Engineers Comments Regarding Surface Water Drainage

Application Reference:	BR/5/26/PL	Reviewer Reference:	ADC/KW/PC
Planning Officer:	Harry Chalk	Date of Review:	27/03/2026
Site Name:	35 Glamis Street, Bognor Regis, PO21 1DJ		
Application Description:	New build 2 storey residential townhouse comprising of 1 No 2b/3p and 1 No 3b/5p flats.		
Assessment Number:	1 of 1

Flood Risk Assessment and Surface Water Drainage Strategy: New-build 3 Storey Townhouse

GROUND FLOOR BLOCK PLAN

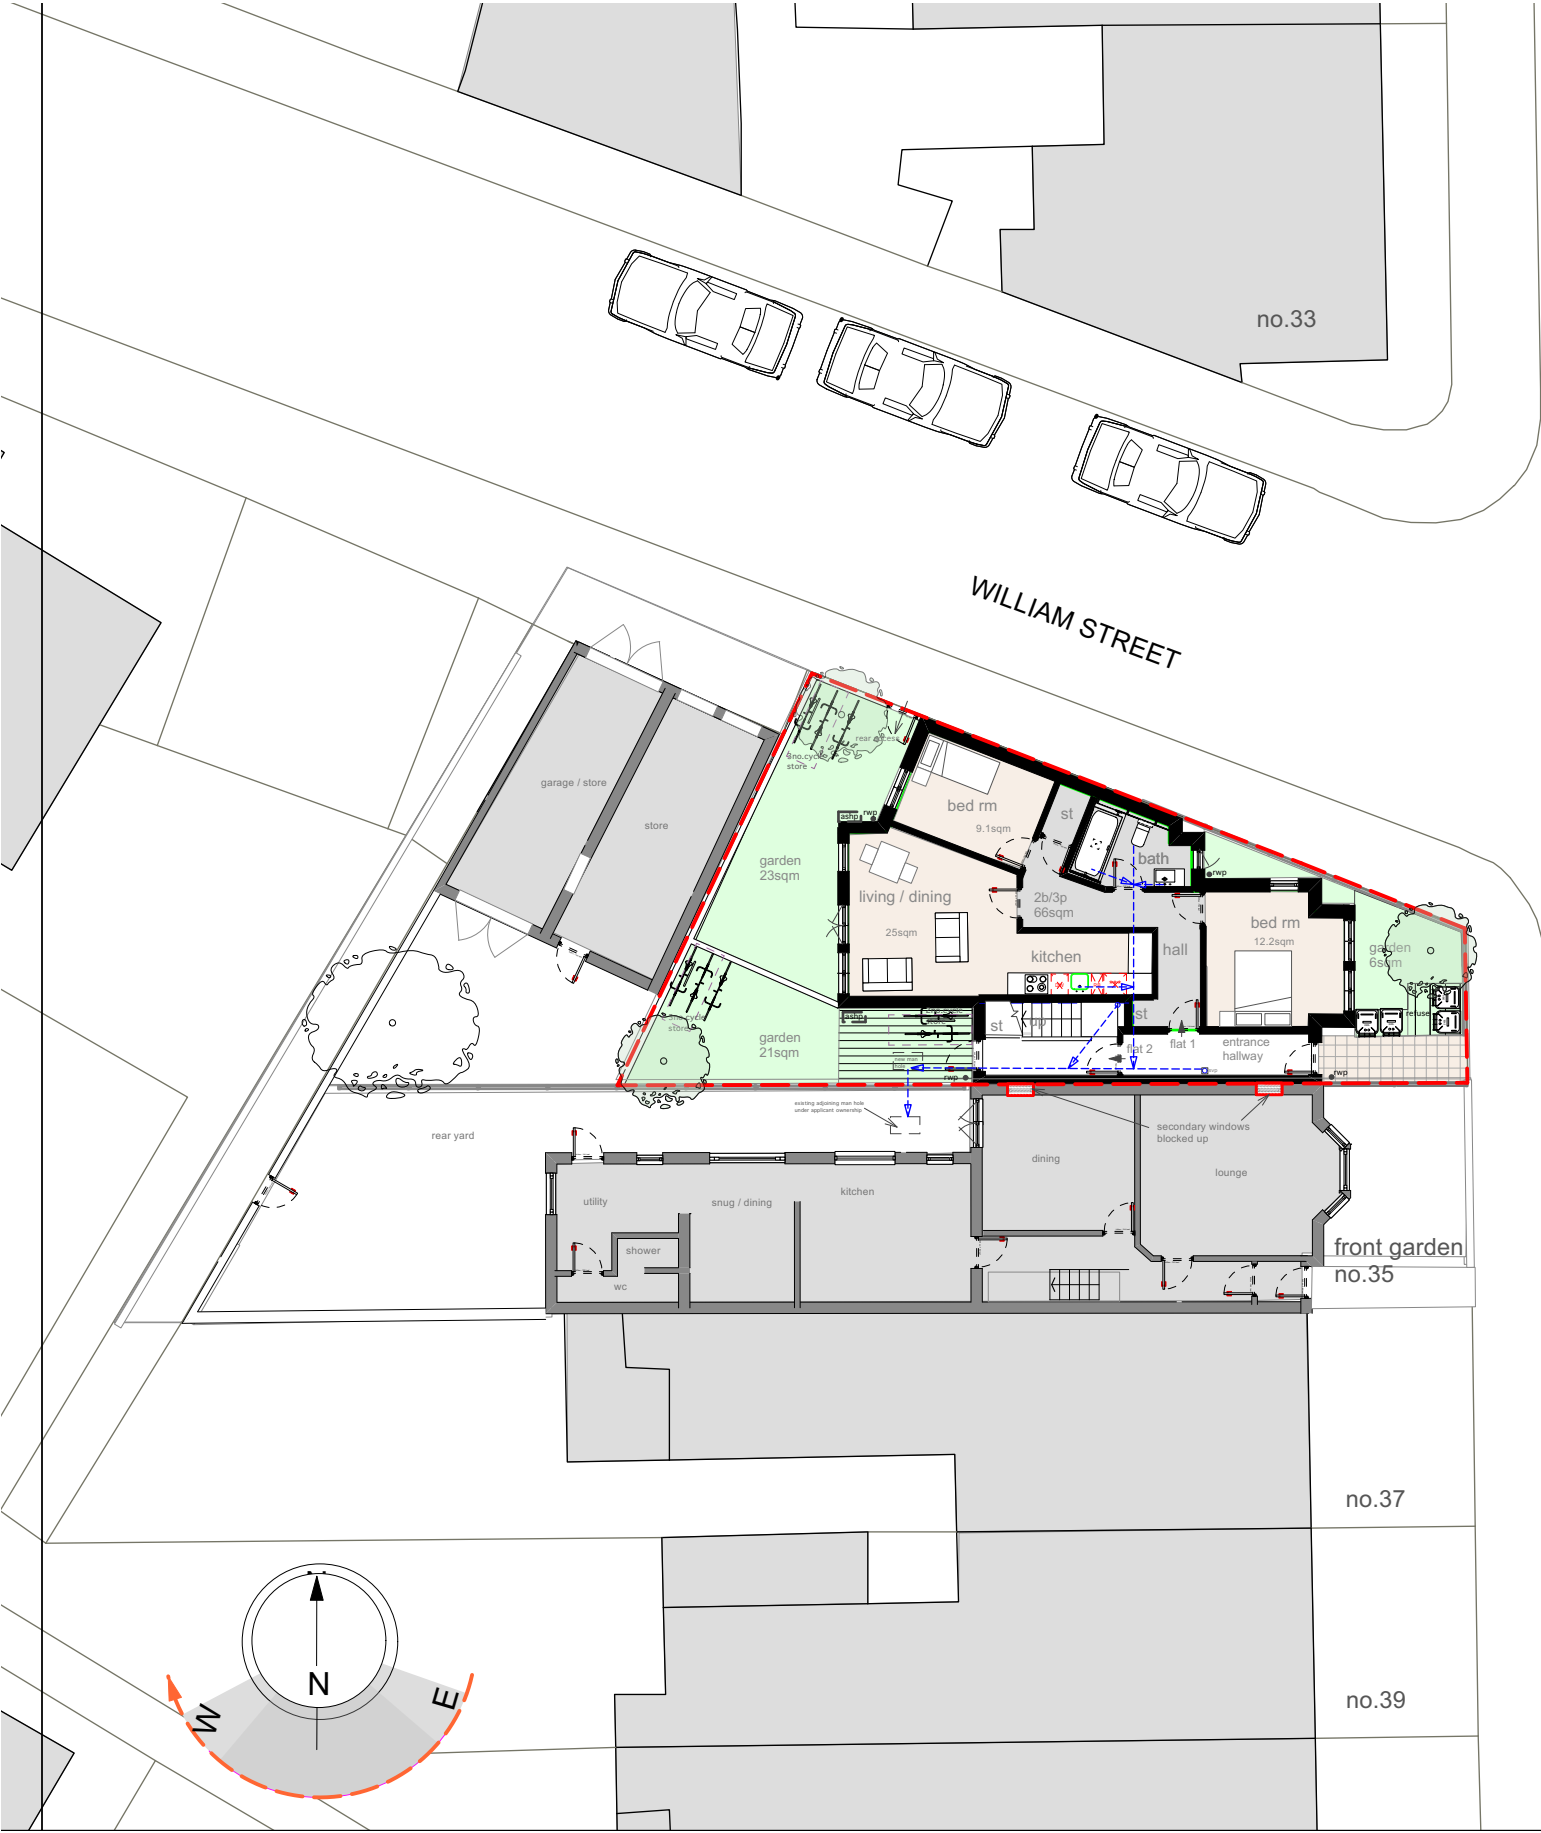
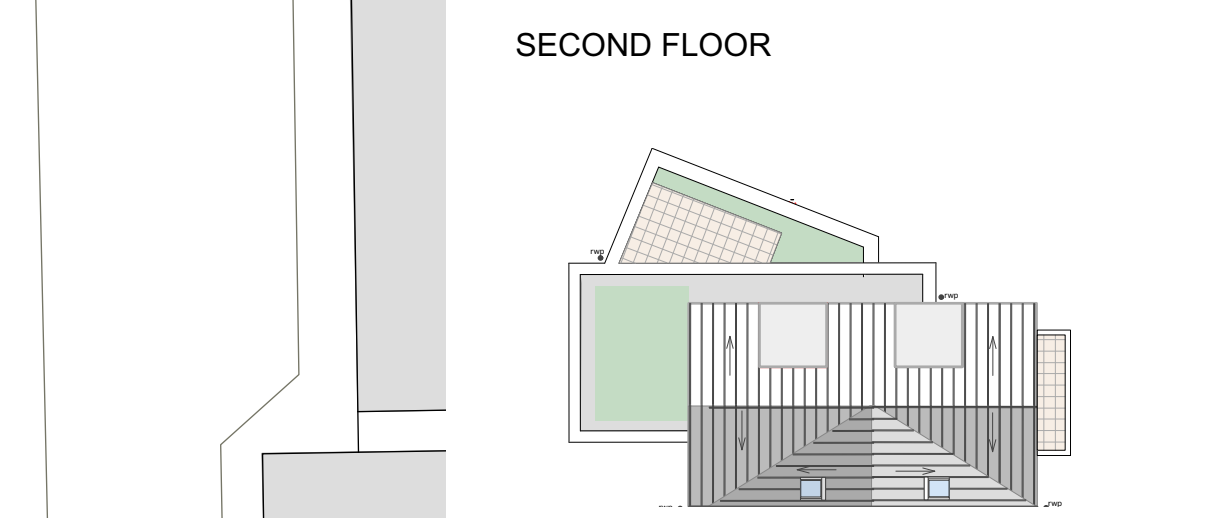
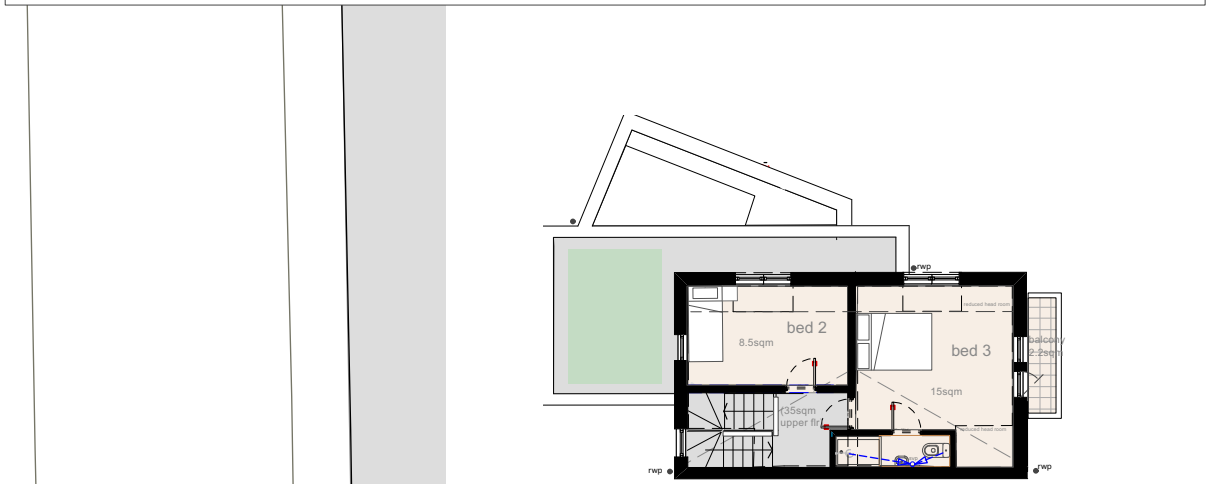
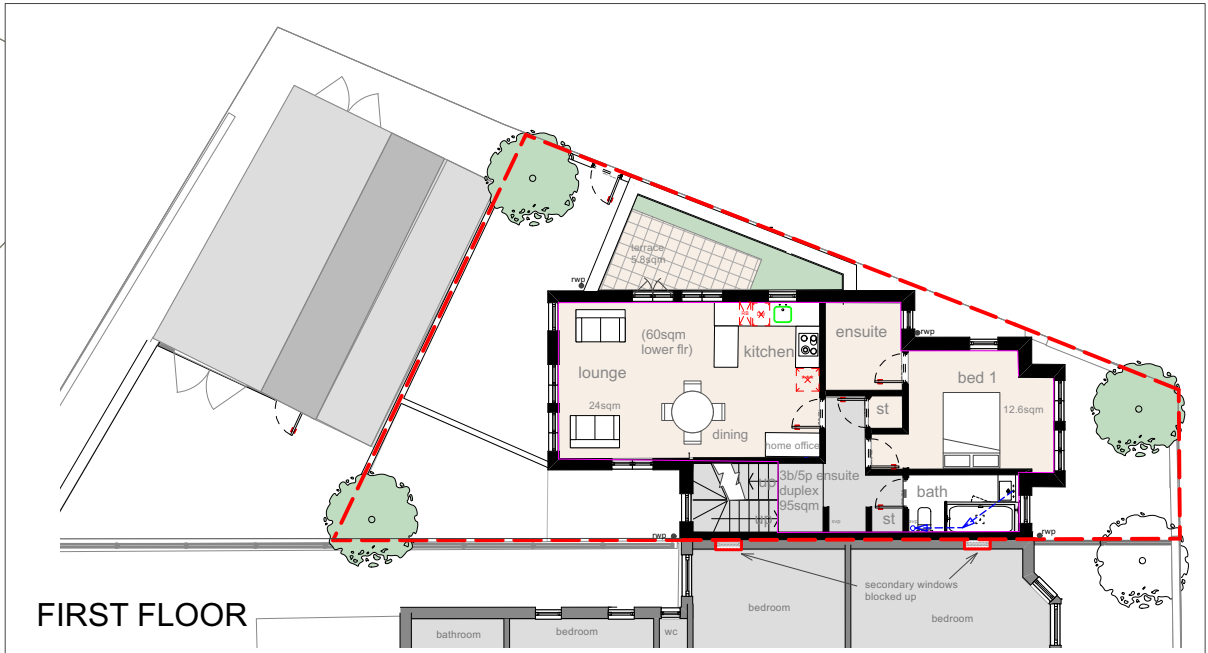
- 1.5. Soakaways must be located at least 5 m from buildings and highways. The block plan indicates that the building will be less than 1 m from the proposed structure and will abut an existing garage. Furthermore, the proposed structure may disrupt existing soakaways on the site, which have not been assessed for the purposes of this submission. If the existing drainage for the property is disrupted and there is no space for an alternative solution, the risk of flooding will increase.
